# WOODMOOR

Water & Sanitation District No. 1

June 07, 2017

**RE: High Pines Patio Homes Phase 2C (SF1714)**  
Residential Subdivision Planning Documents (5 sheets) REVIEW 1

FINAL PLAT
 HIGH PINES PATIO HOMES
 PHASE 2C

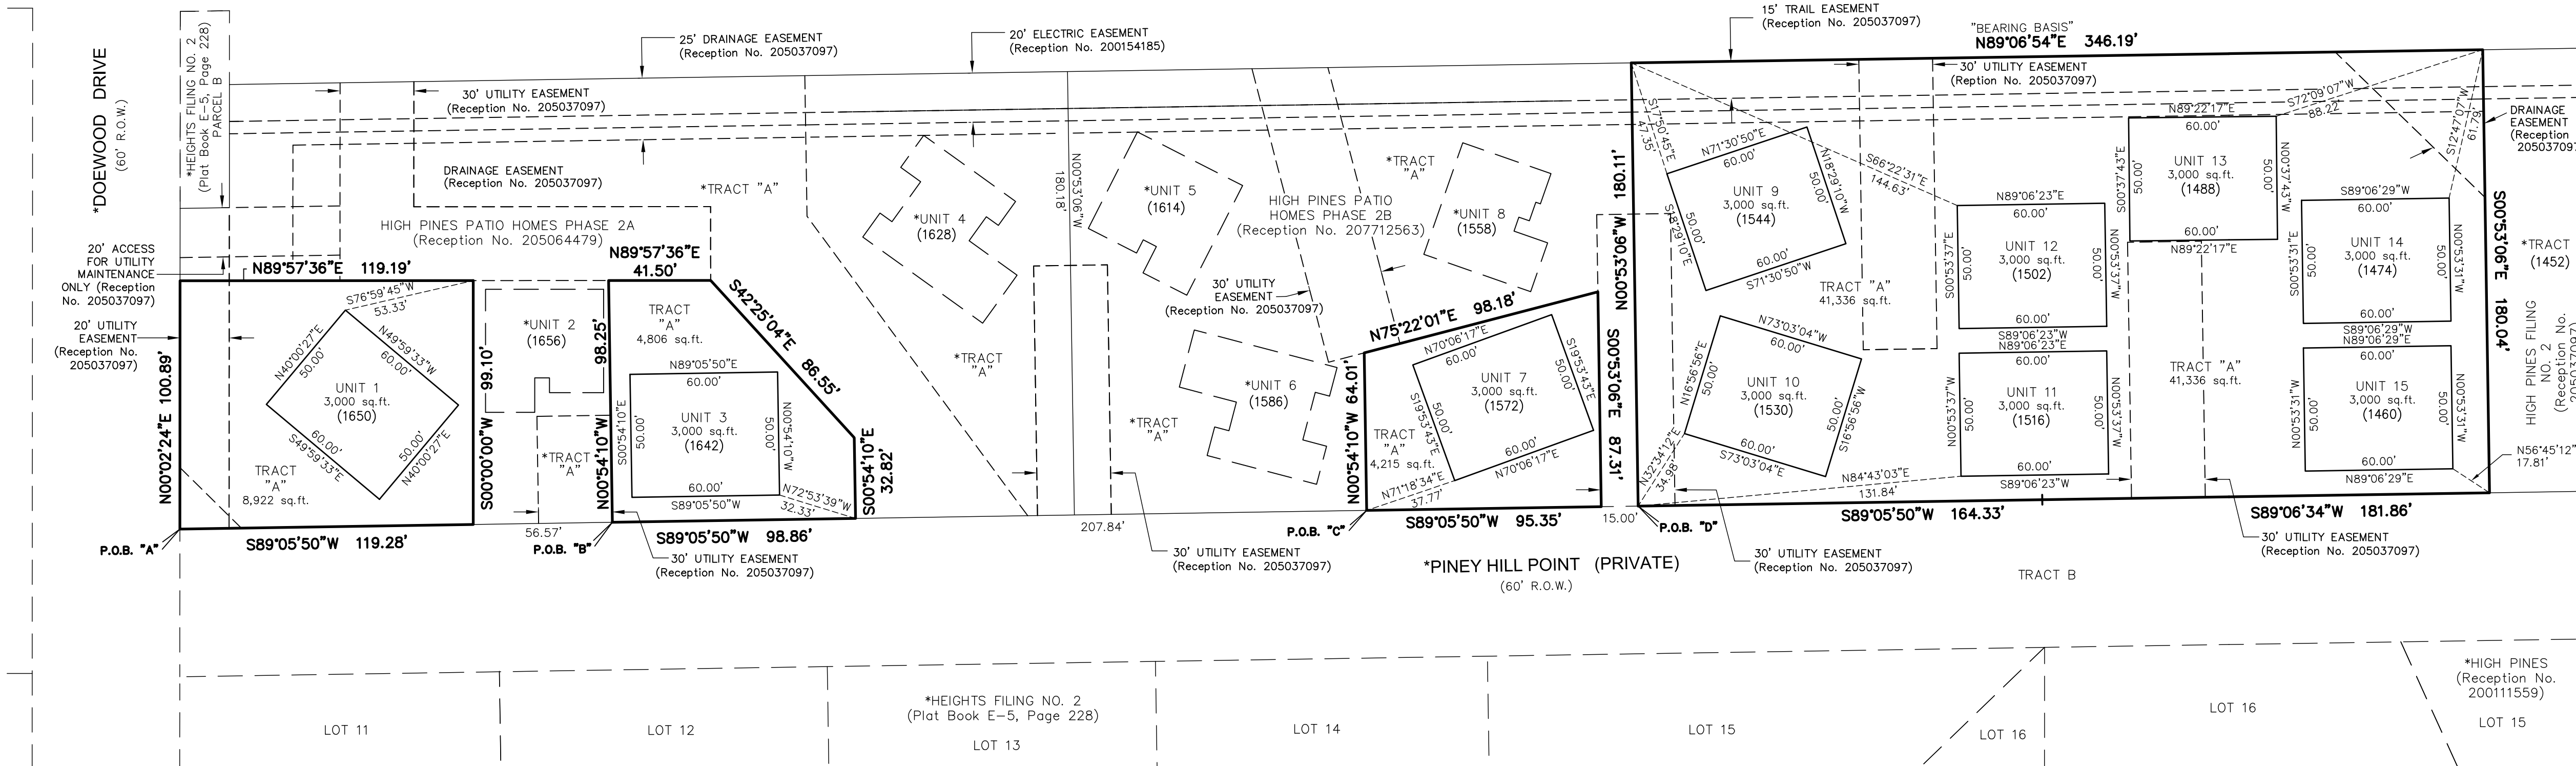
2. In accordance with the recorded Easement Agreement (reception #206105039), WWSD has the right of ingress and egress to the premises "for any purpose necessary for the construction, reconstruction, operation, use, maintenance, repair, replacement and/or removal of the Improvements." Please revise note 13 as appropriate.
